EPC STORMWATER REVIEW COMMENTS  
IN ORANGE BOXES WITH BLACK TEXT

**Preliminary Drainage Report**  
**Meadow Lake Industrial Filing No. 1**  
**El Paso County, Colorado**

August, 2023

PCD File No. TBD **SP236**

EX DRAINAGE MAP

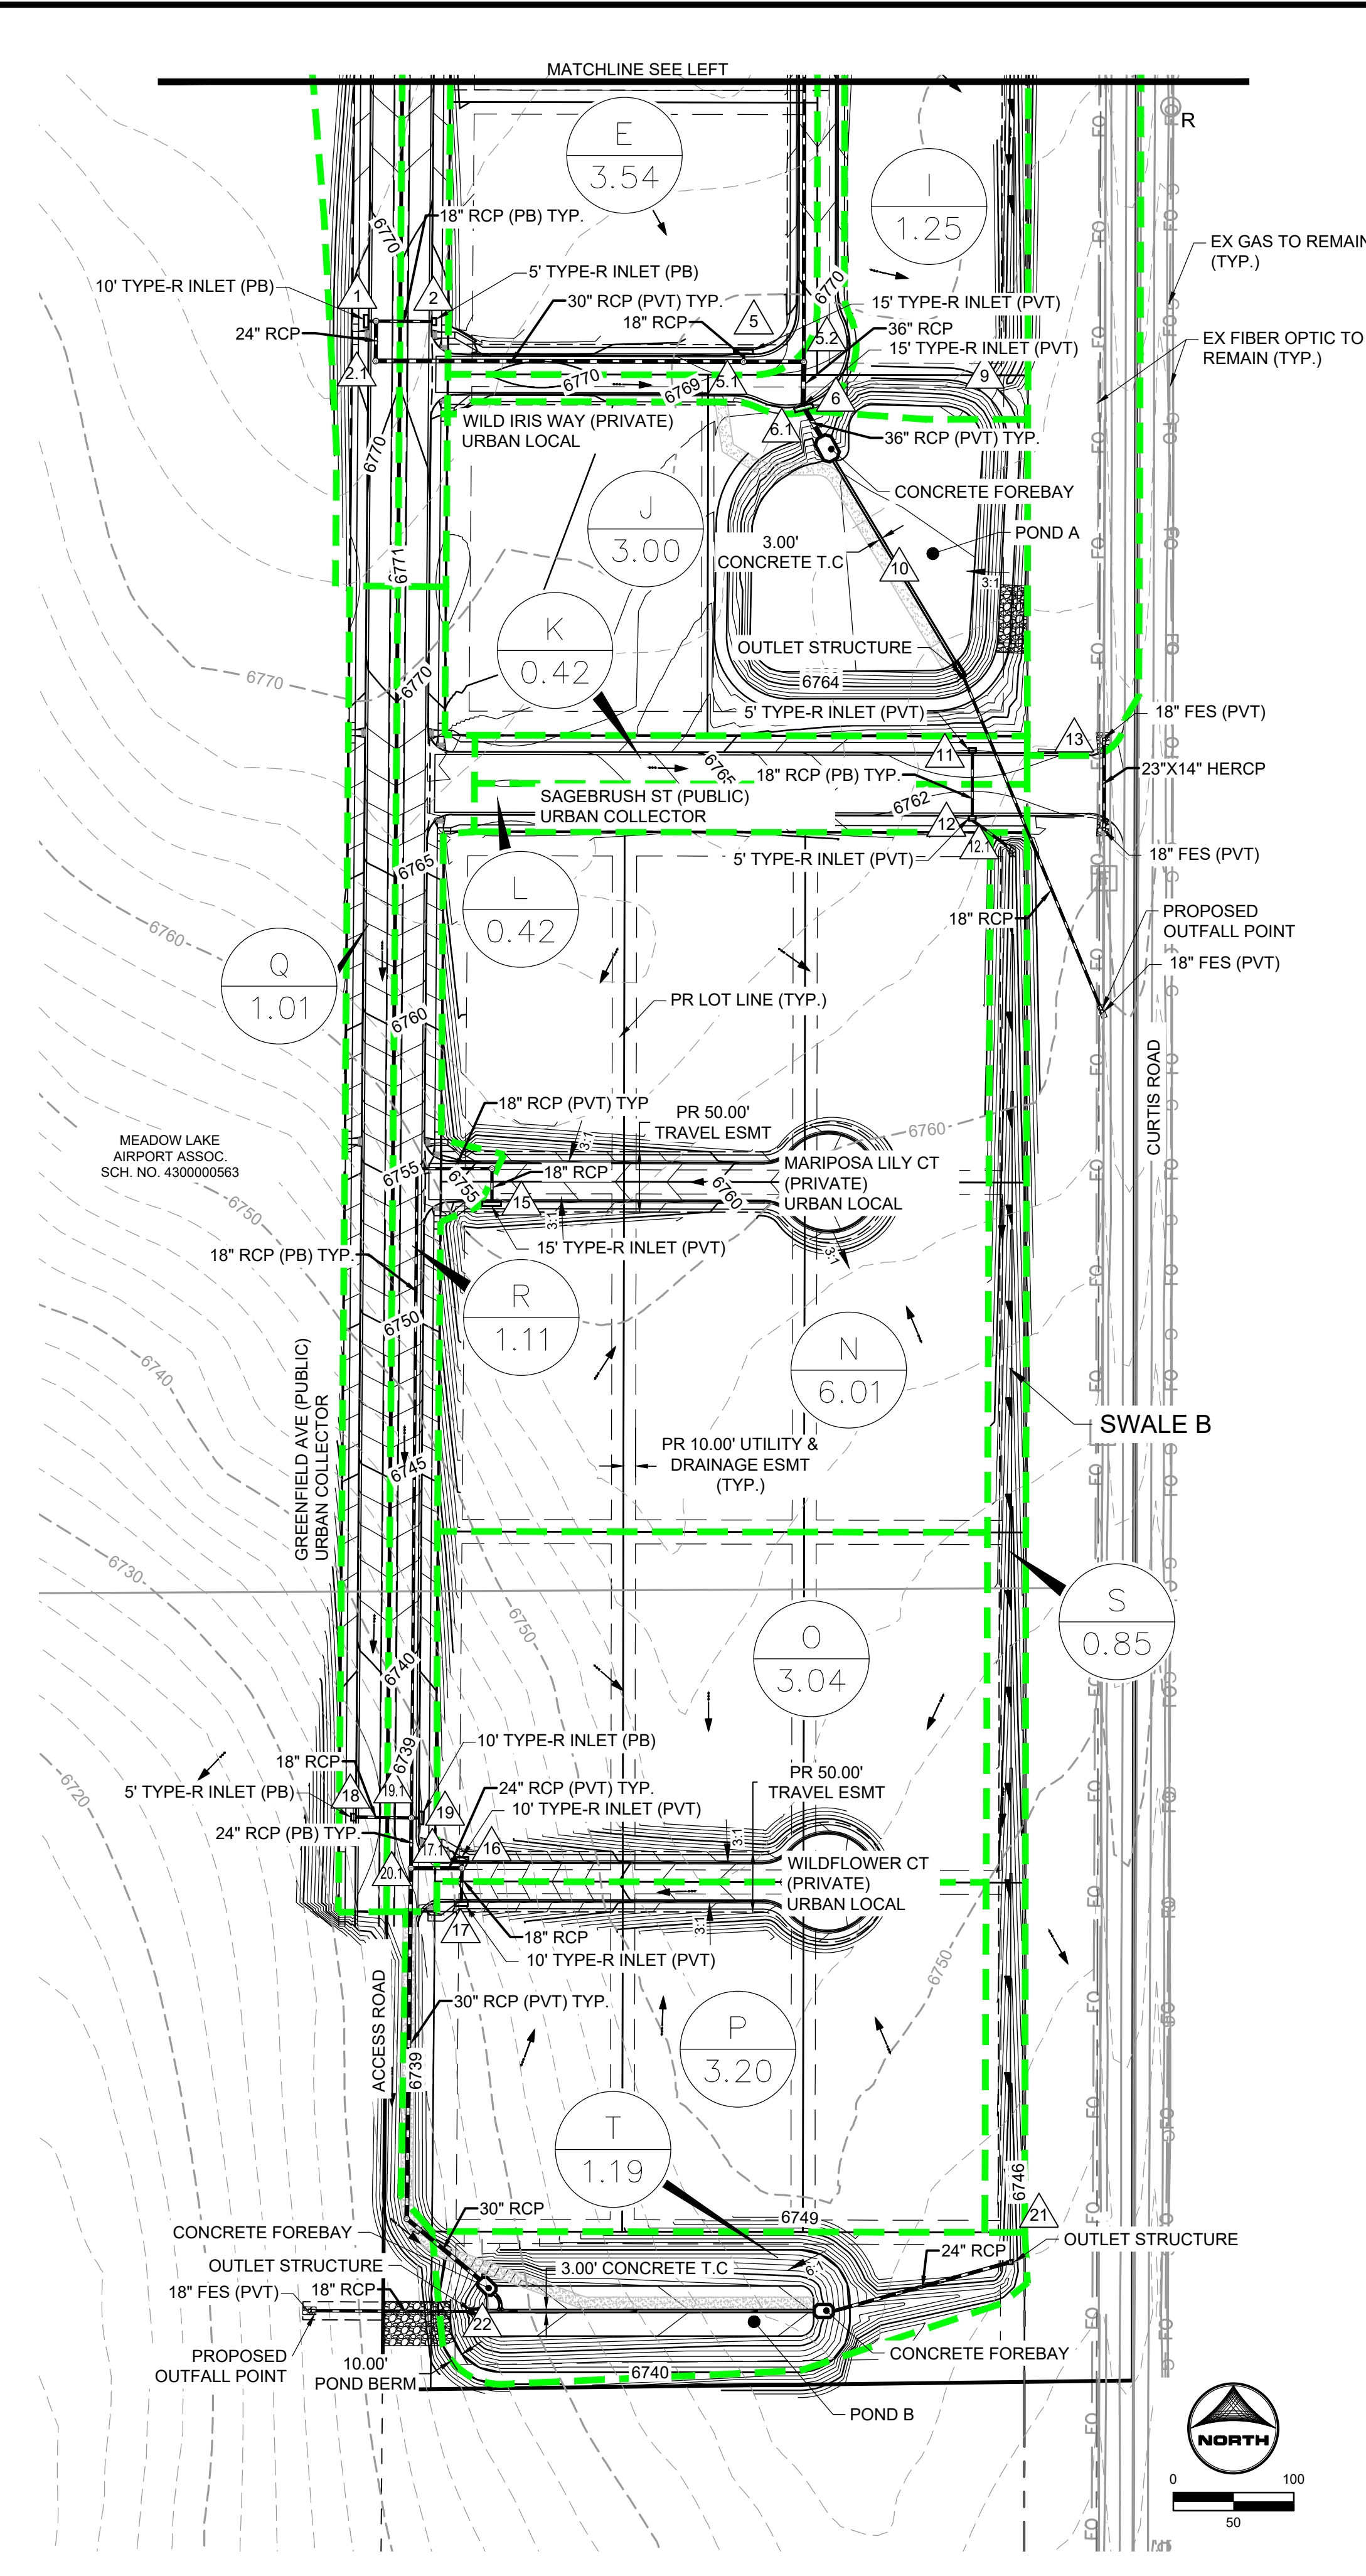
These existing drainage basins are much larger than the proposed. The existing and proposed basins should be looking at approximately the same areas for comparison between the existing and developed conditions.

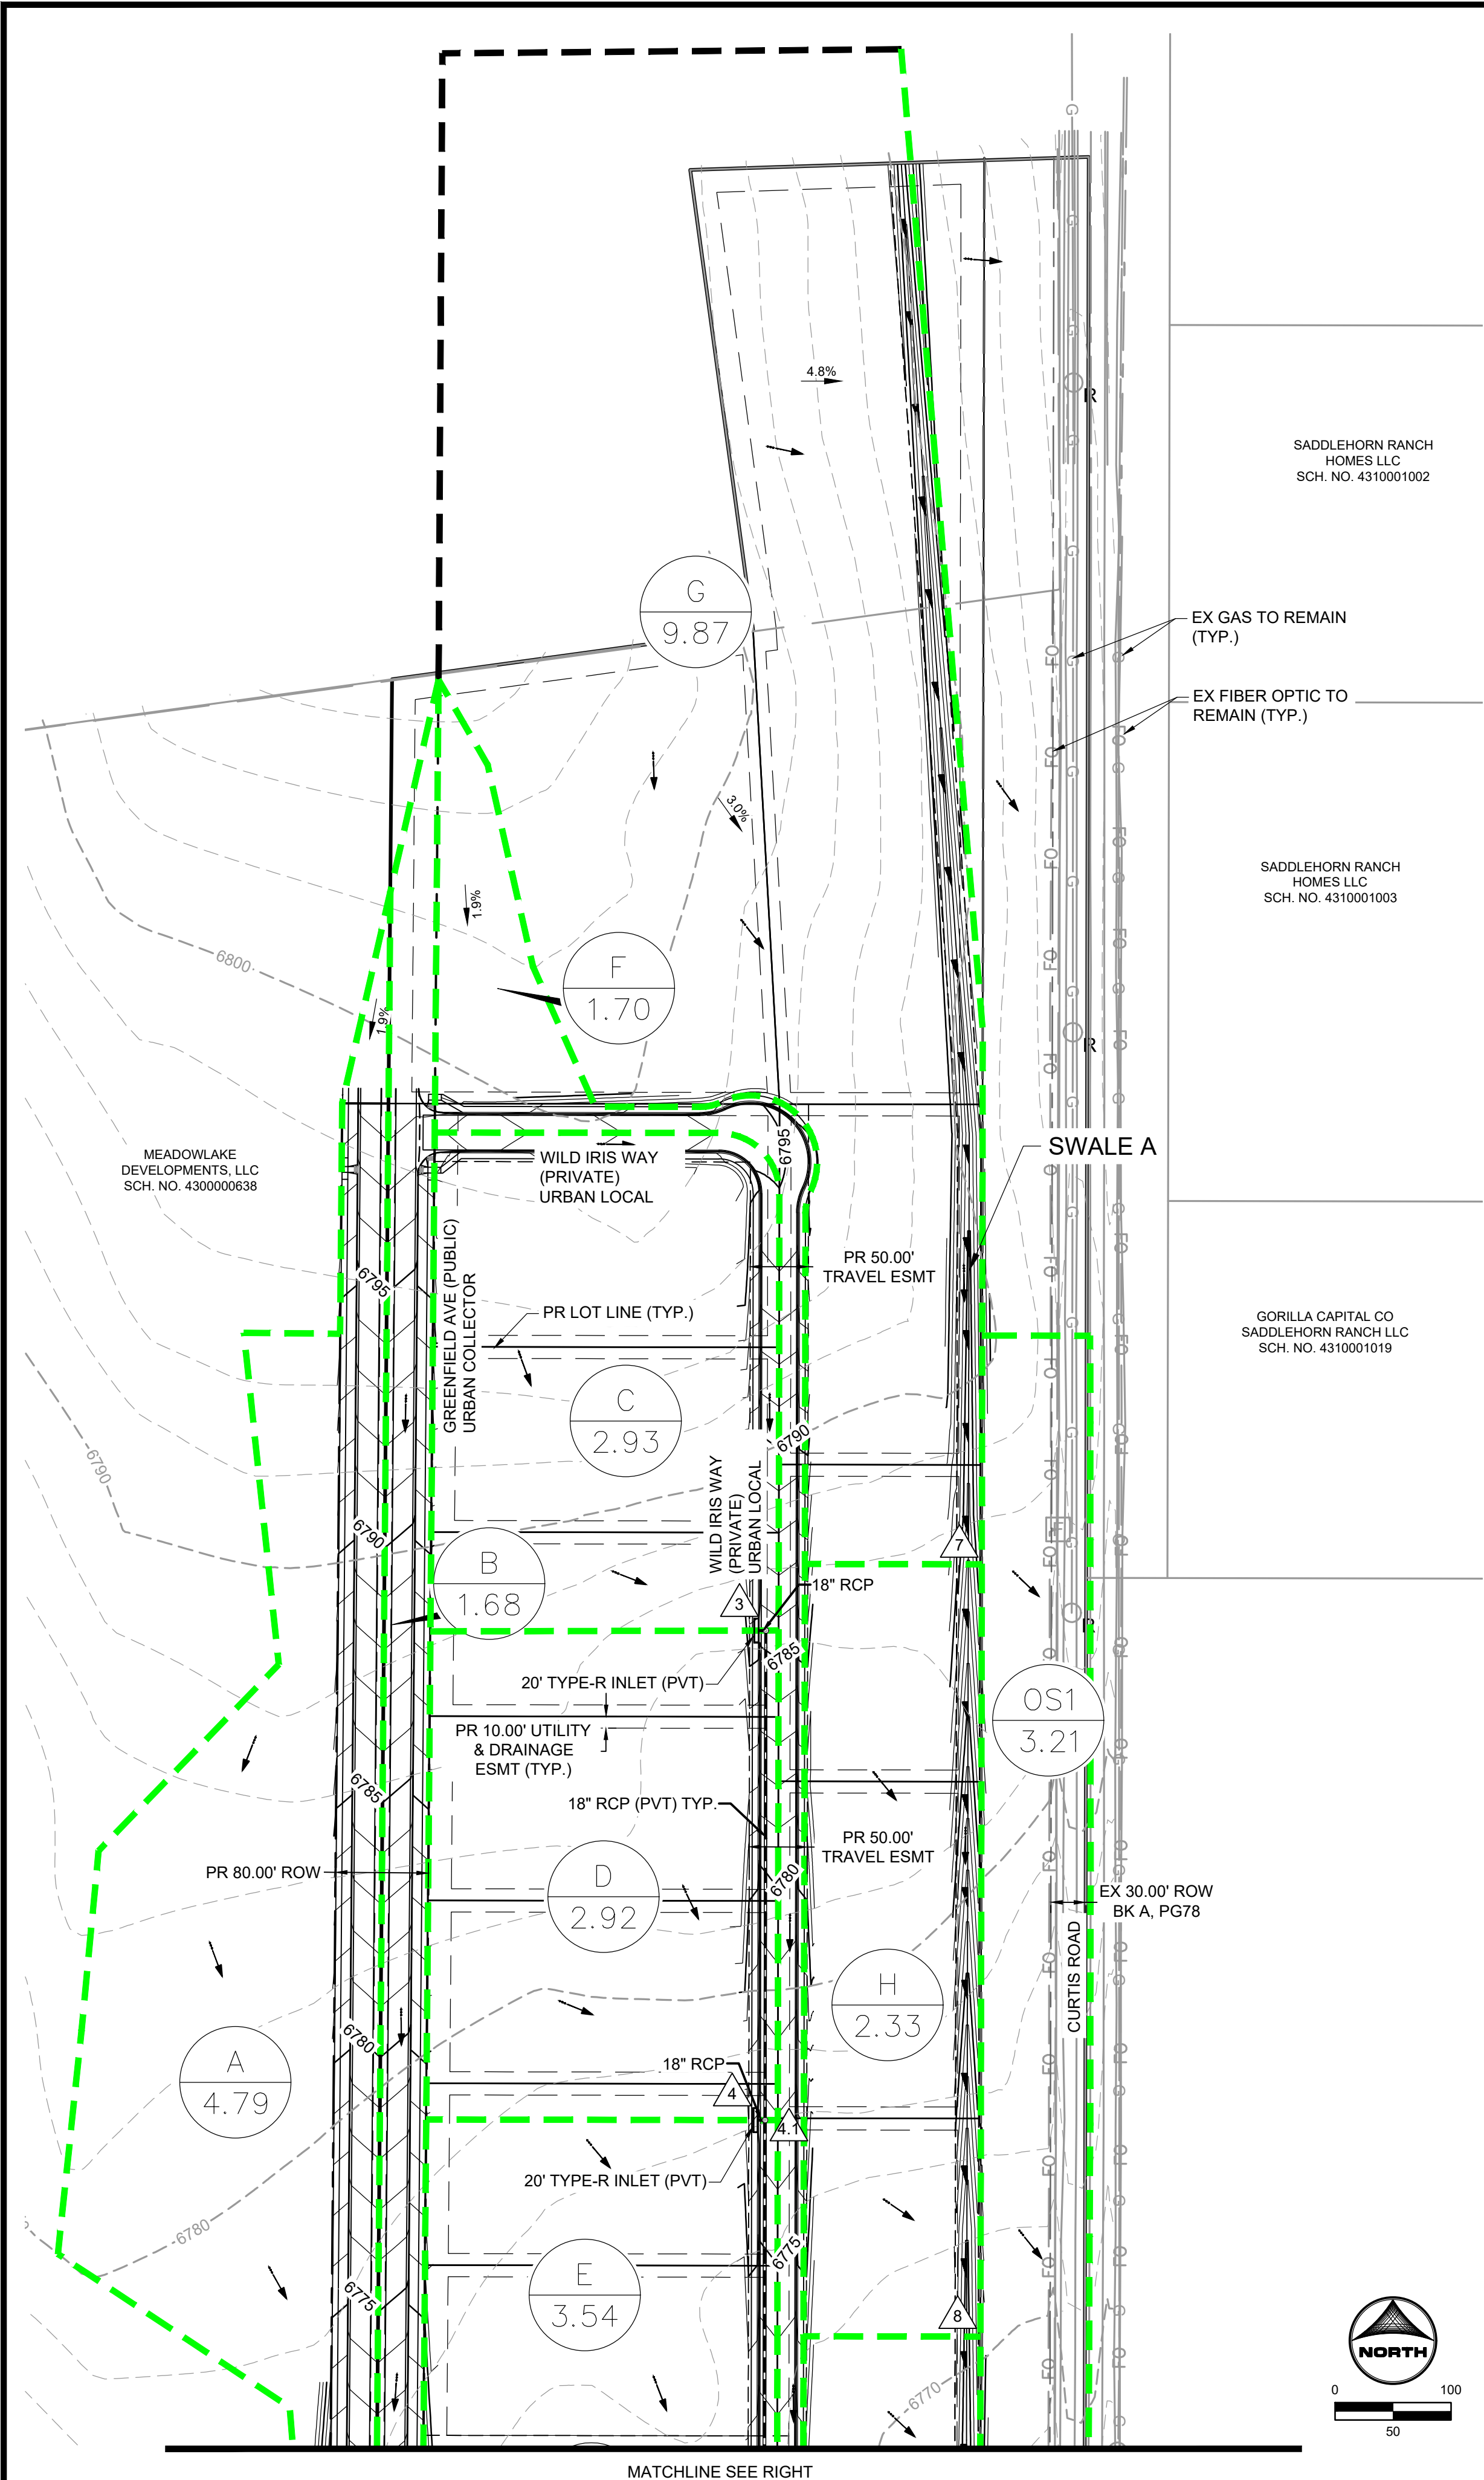
it does not appear that there is undeveloped area in basin B as it is all lots and roadway. revise

Revise to include offsite runoff that drains to this basin.
